As with the public consultation, Gate Burton Energy Park Ltd has applied the principle of a Rochdale Envelope as an excuse not to provide detailed evidence on their application. Instead of applying a "cautious and worst case approach" they have not provided any detail on major aspects of their scheme in the draft Development Consent Order.

TPO and Hedgerow Removal Plan
Document Reference: EN010131/APP/3.8
January 2023

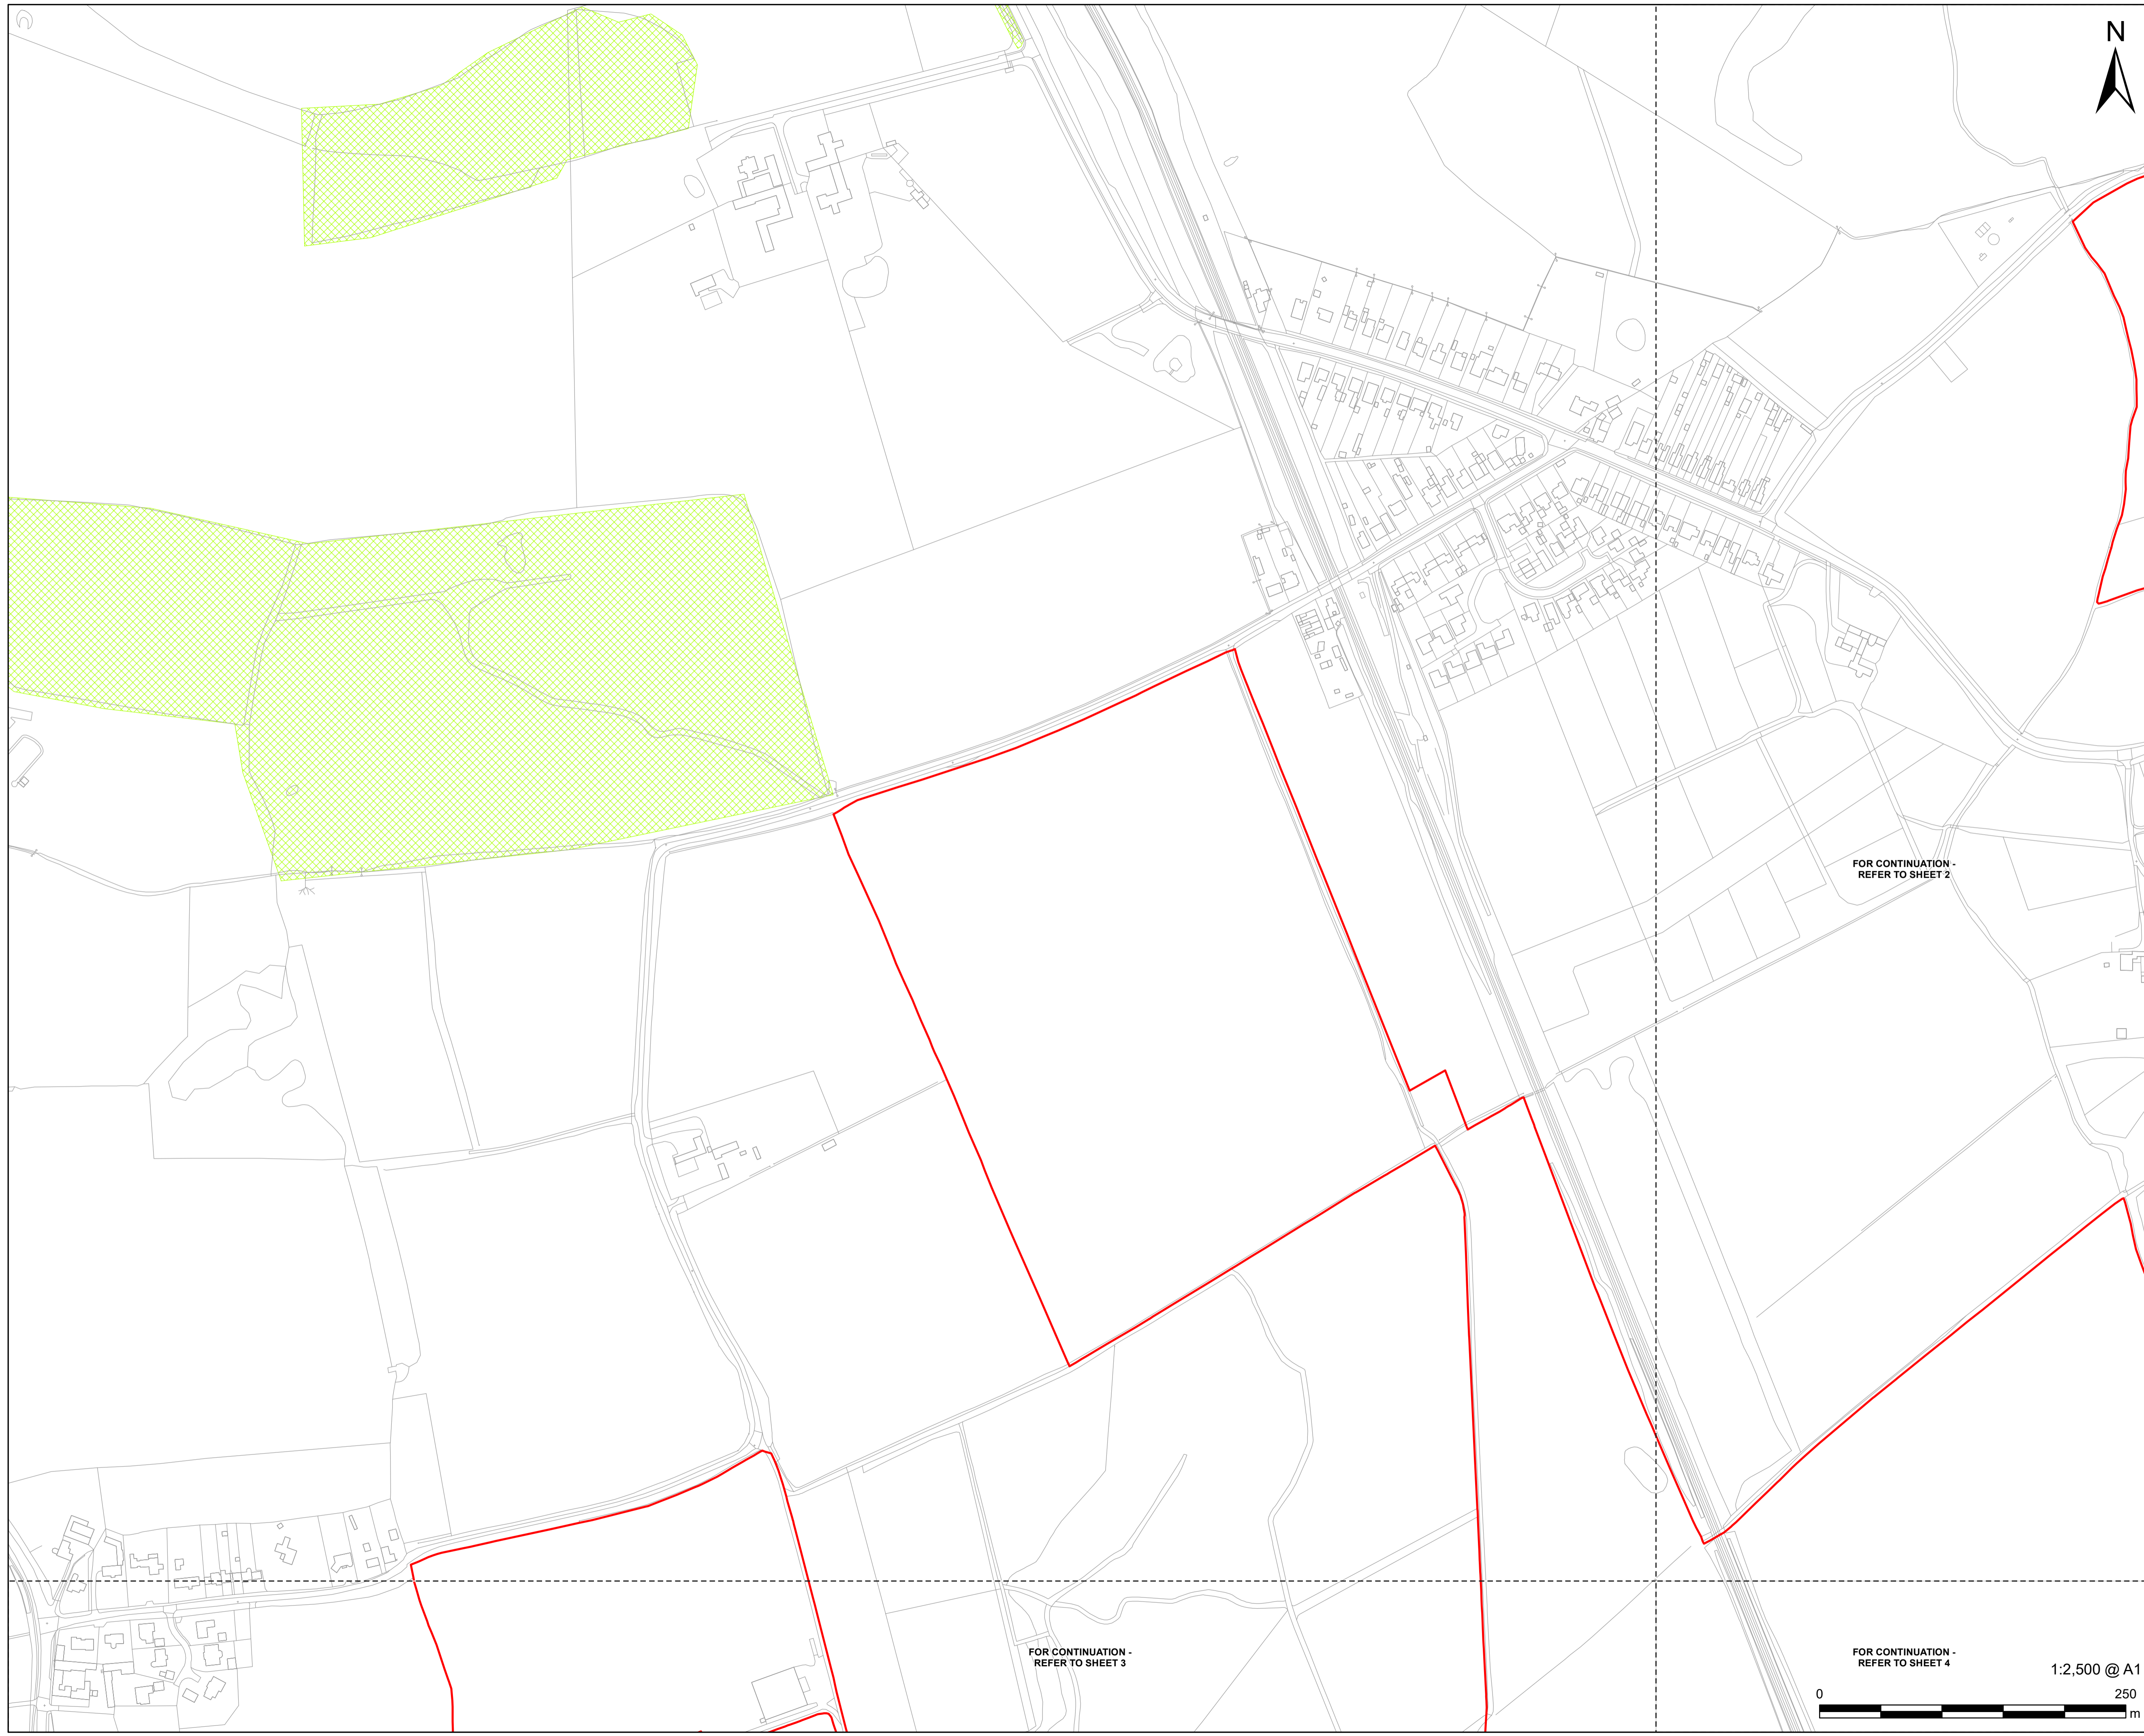
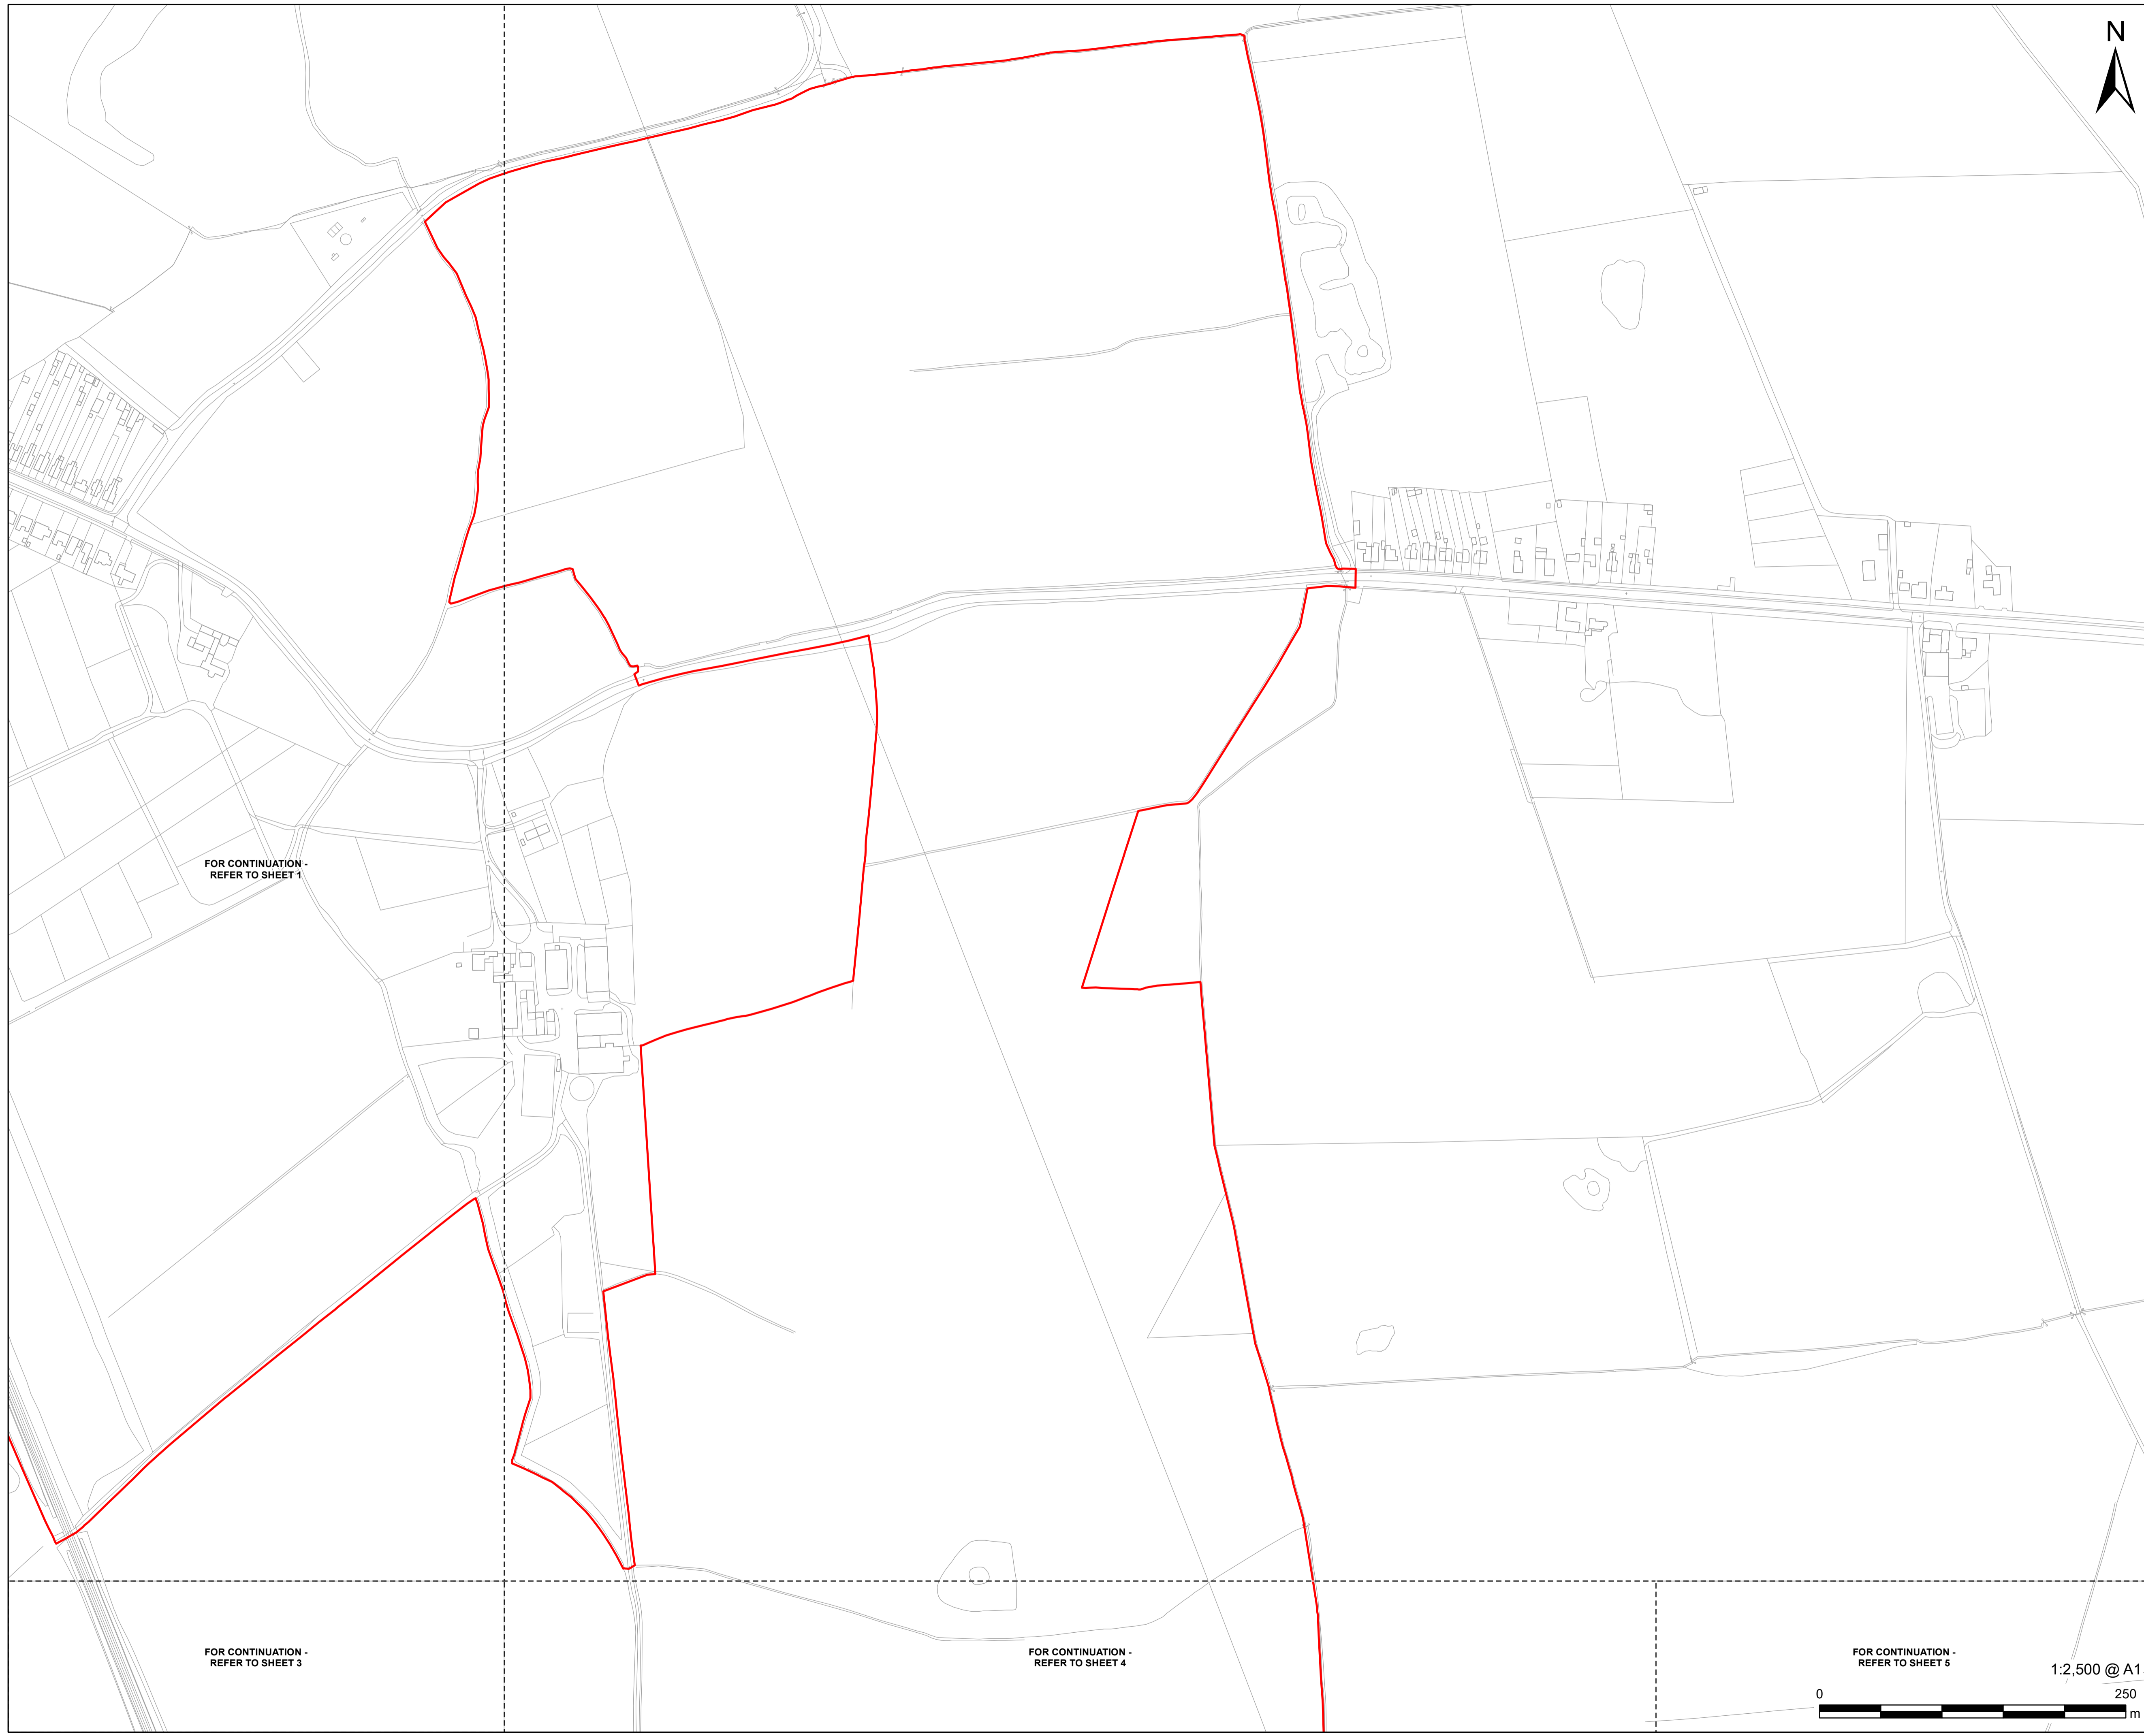
- No information on the scale of hedgerow and tree removal is provided. The adjacent Cottam dDCO provides full disclosure of the circa 55km of hedgerows to be destroyed.
